MetroLink Opening Statement Fingal County Council

This statement follows on from Fingal County Council's written submission to An Bord Pleanála (ABP) in June 2023 regarding MetroLink Railway Order.

Drawing Title	METROLINK - STRUCTURES ESTUARY STATION PROPOSED STREET LEVEL DESIGN		Drawing Status	S0
Drawing N°	ML1-JAI-SRD-ROUT_XX-DR-Y-02001	Plan Drawing N°	ML-ST 301 B-C1	
Scales Original Size A1	1:250	Sheet	1 of 5

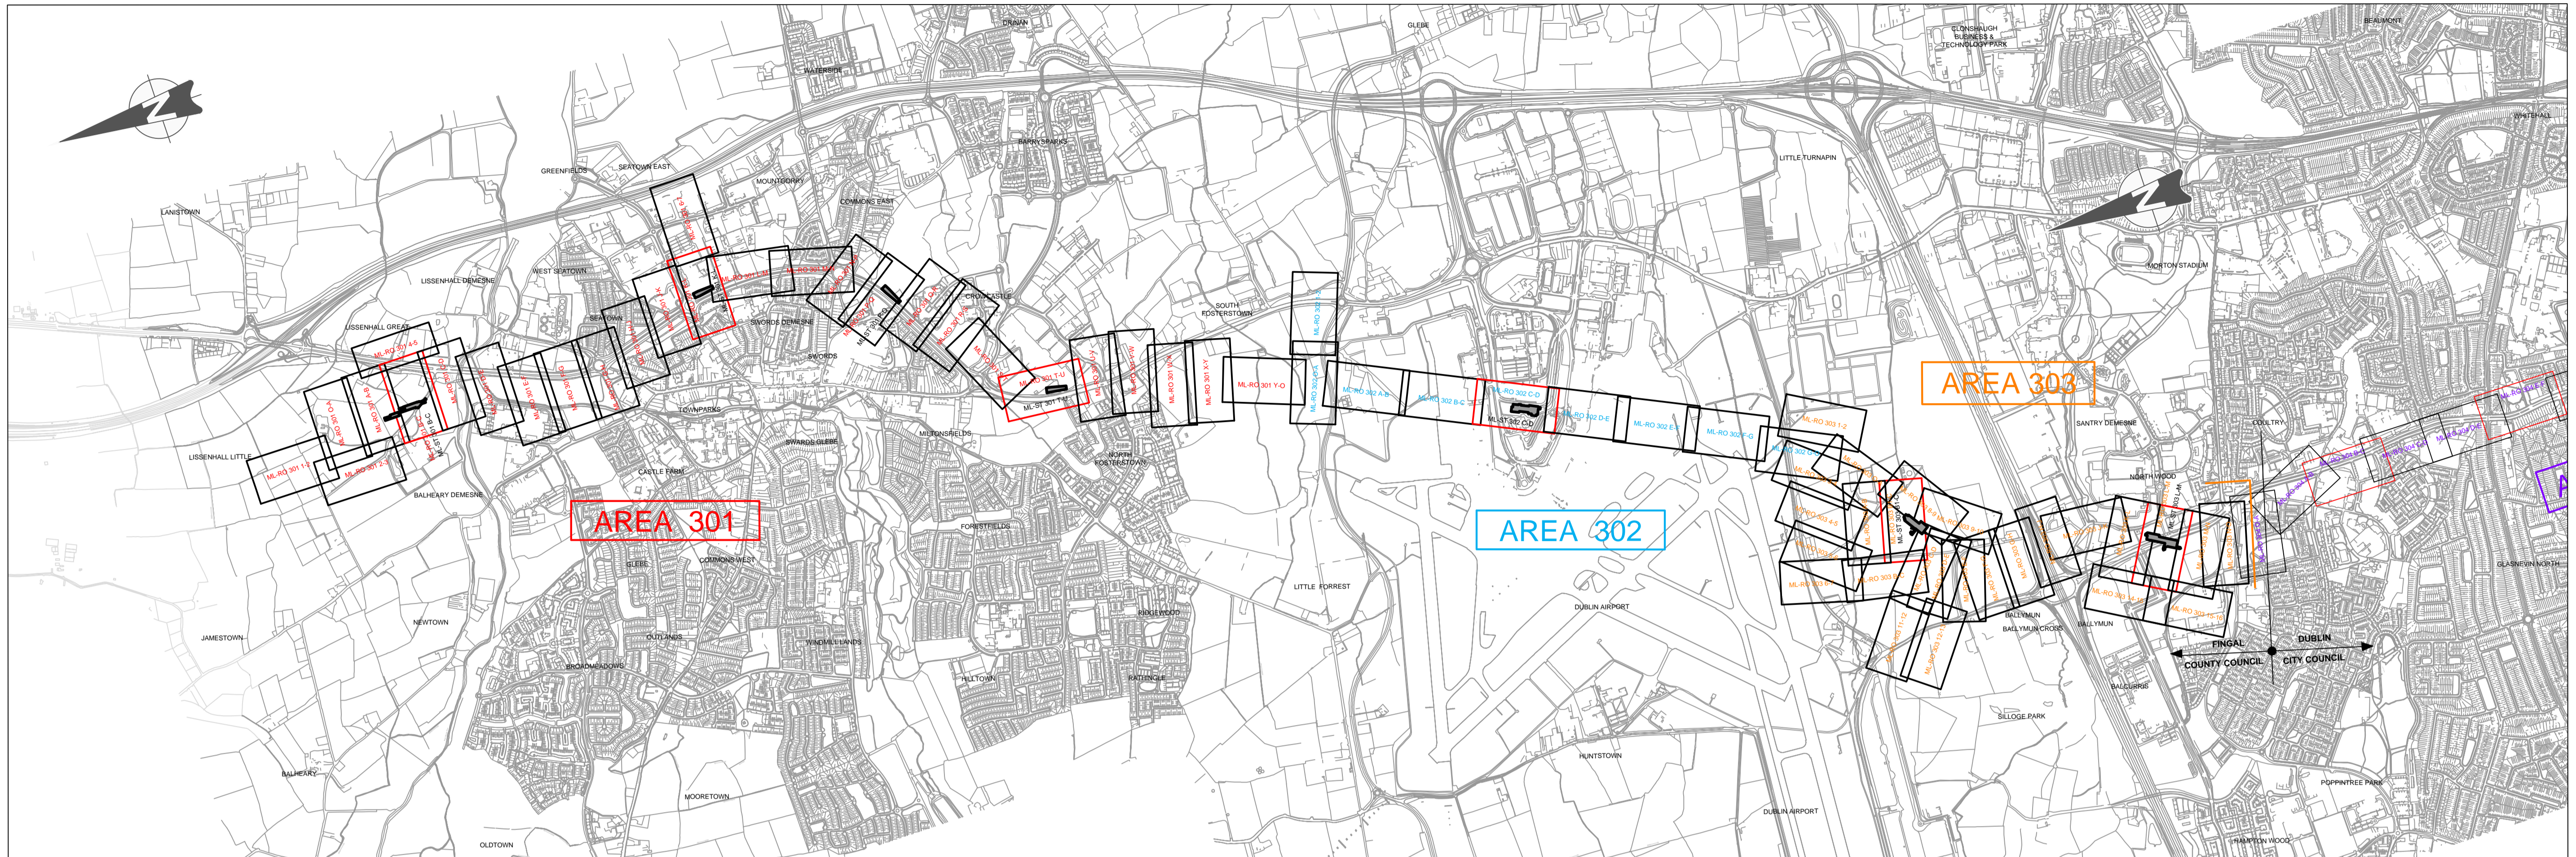
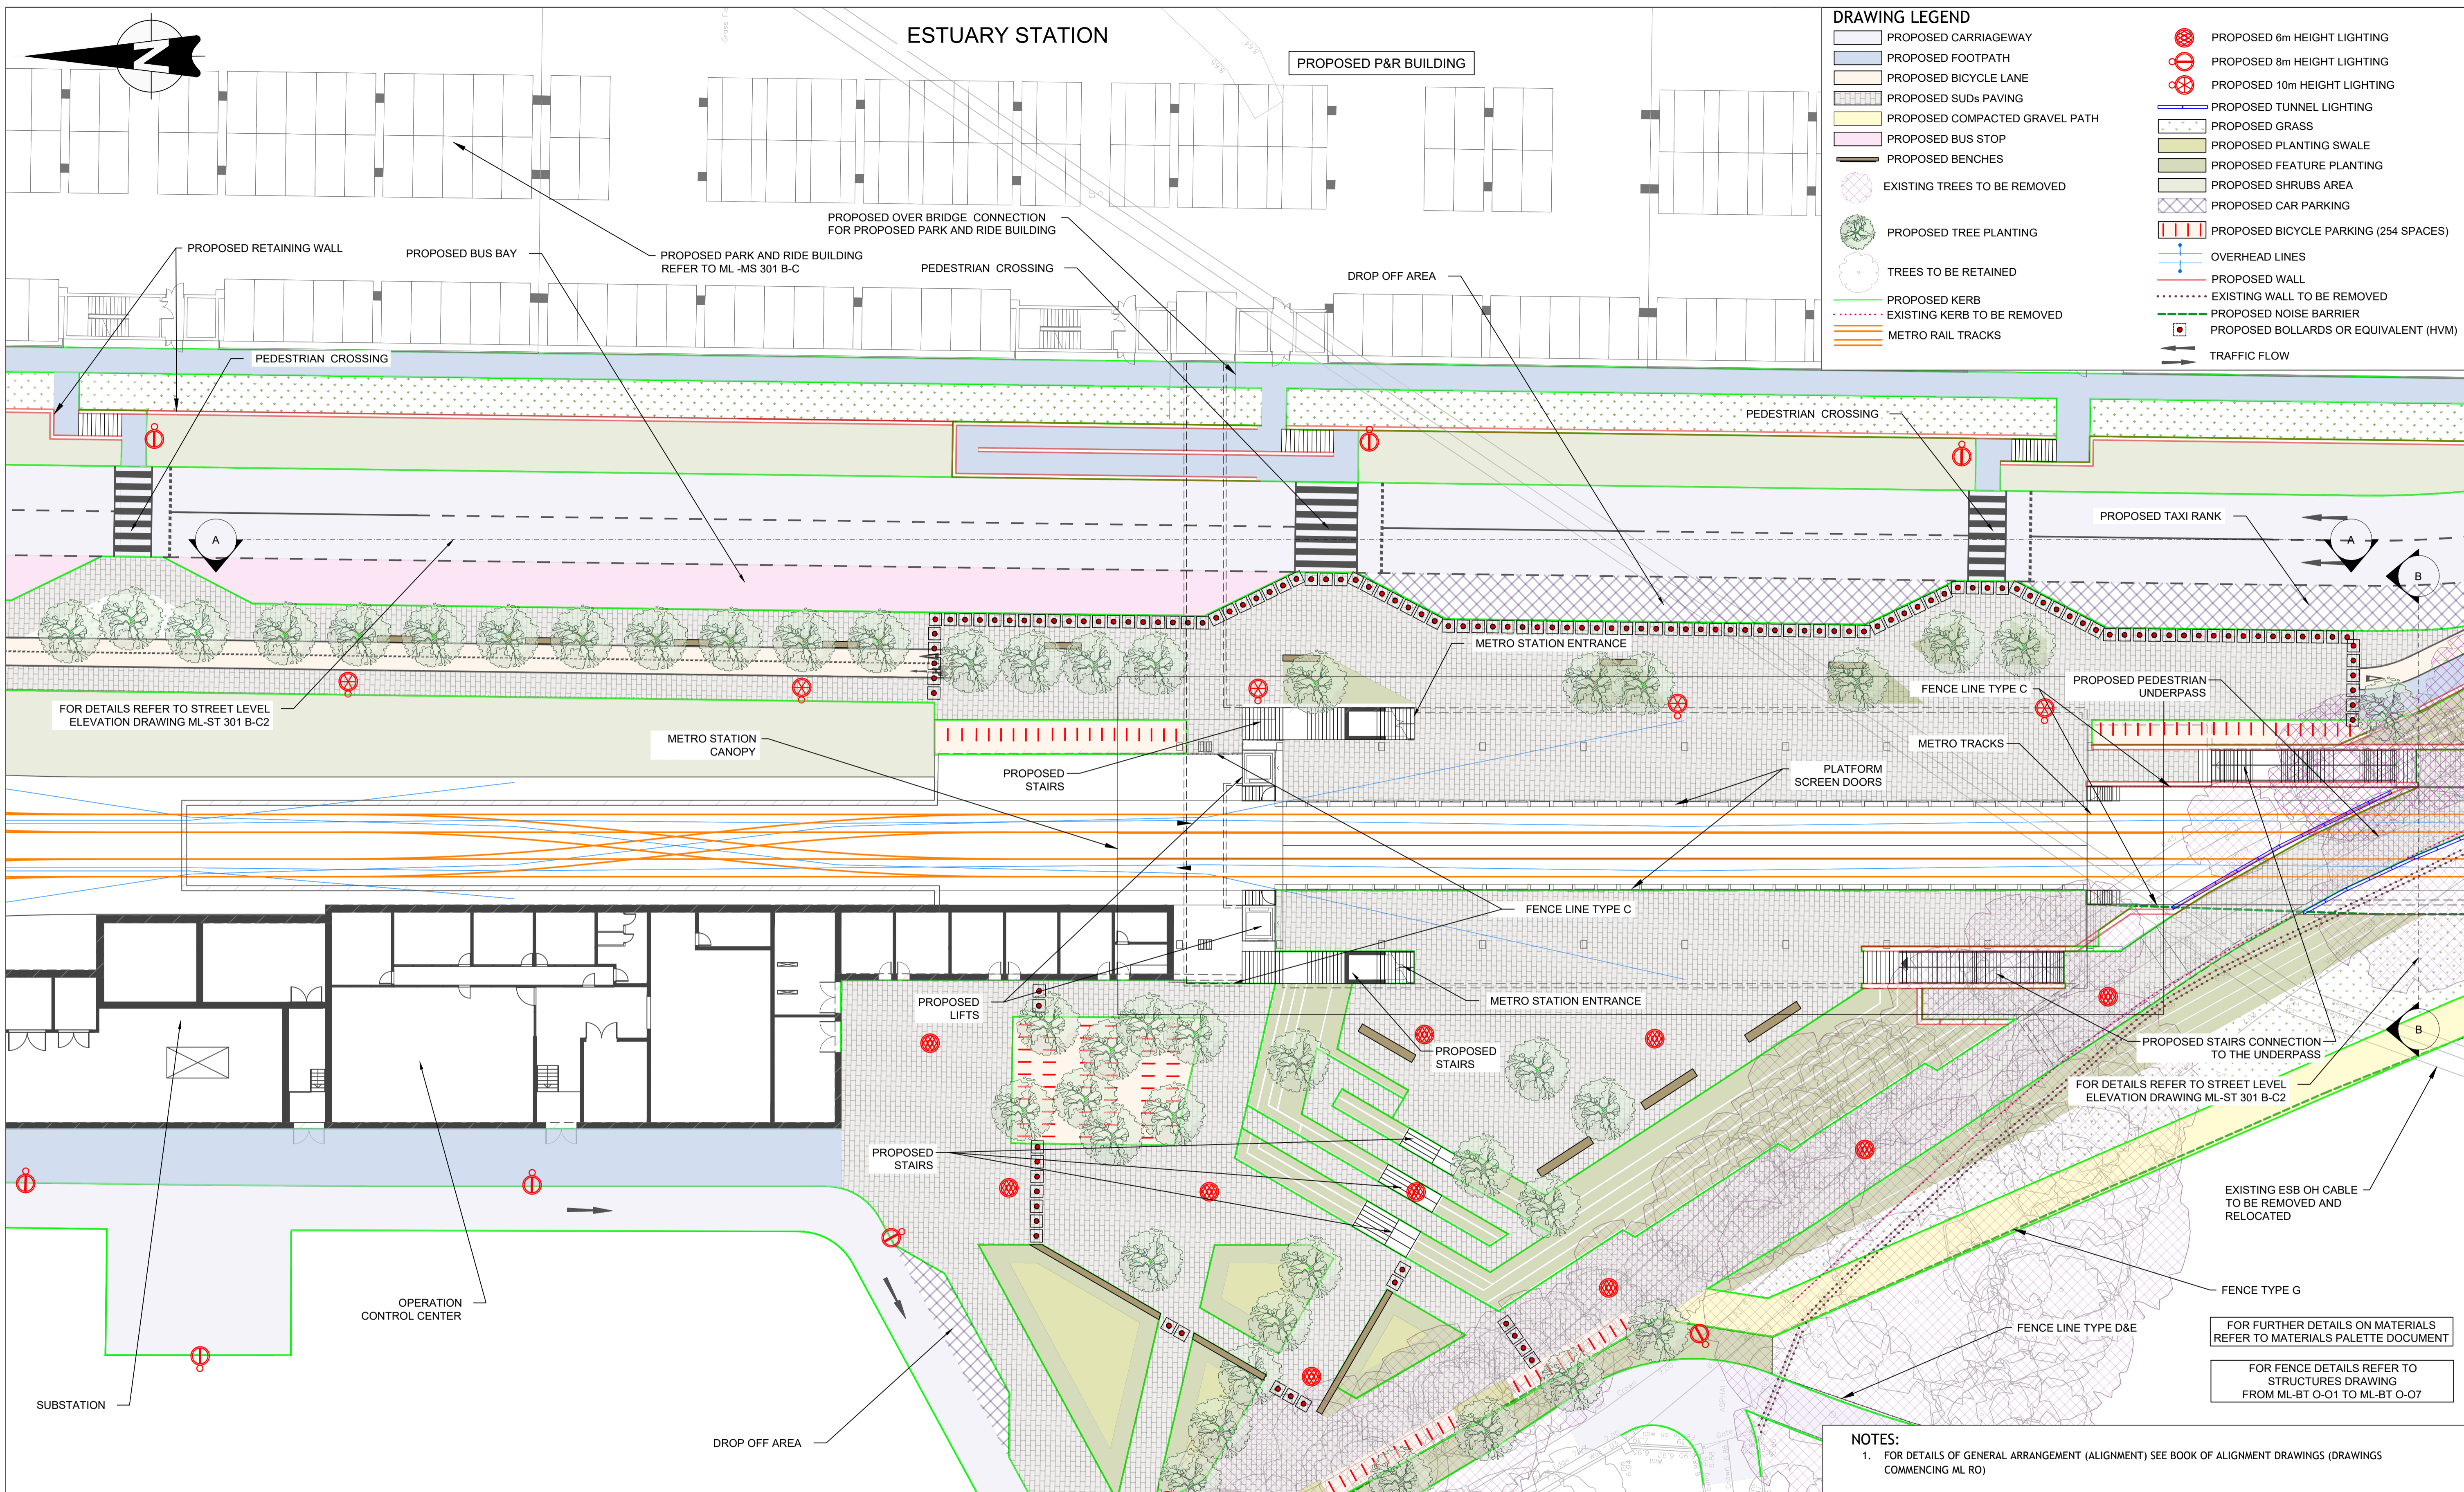
Separately at the Estuary stop, Fingal County Council has raised concerns in relation to the number of bicycle parking. The proposal of 252 bike spaces appears insufficient and does not reflect the substantial development of a new urban neighbourhood which will be created at

this location. Through further discussions with TII and FCC, TII has committed to the provision of a more appropriate level of bicycle parking spaces, which are of high quality, safe, secure, and located with ease of convenience to Estuary Station.

DUBLIN AIRPORT STATION

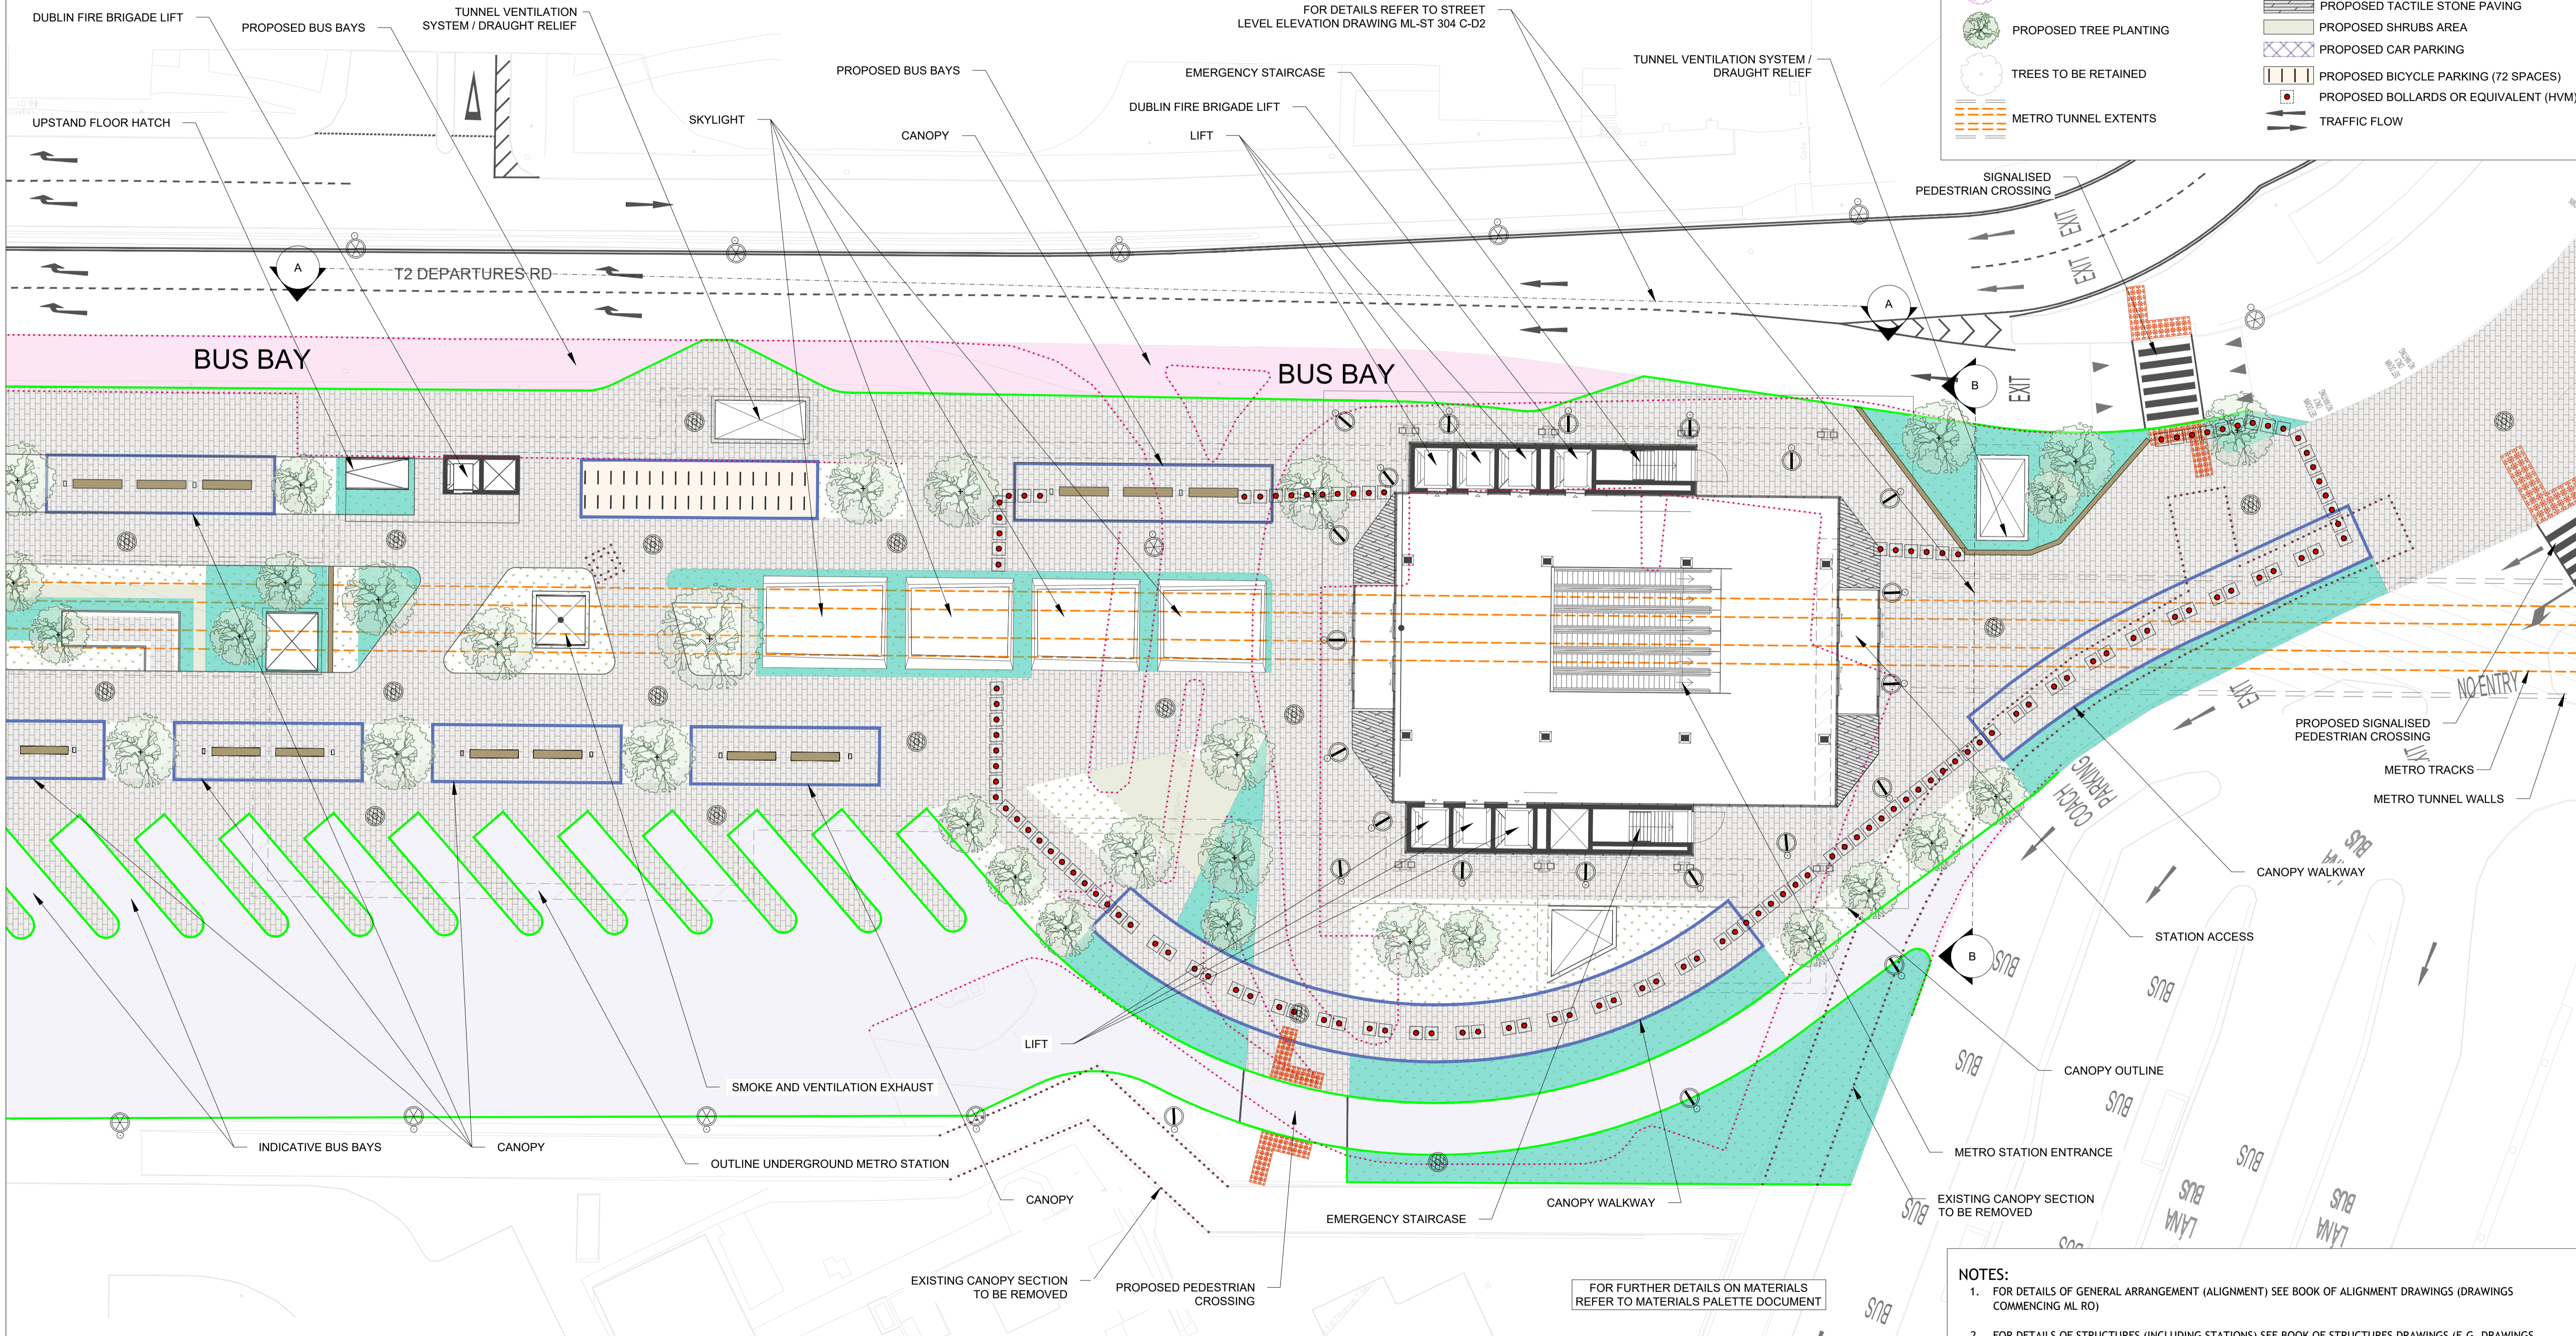
At Dublin airport, Fingal County Council has raised concerns regarding the MetroLink surface connection within the airport and both the building and the setting of the Protected Structure of the Church of Our Lady Queen of Heaven (RPS No. 864).

The surface connection within the airport has rows of bus parking bays in proximity to the protected structure which between the MetroLink proposal and the proposal contained in the current Dublin Airport Infrastructure Planning Application (F23A/0781) is now presented as having parking infrastructure on three sides.

The design of the surface treatment and landscaping of the area around the Metro Station Entrance needs to be integrated into an overall Ground Transportation Centre design which is sensitive to the location and setting of a protected structure of national significance (Church) within it.
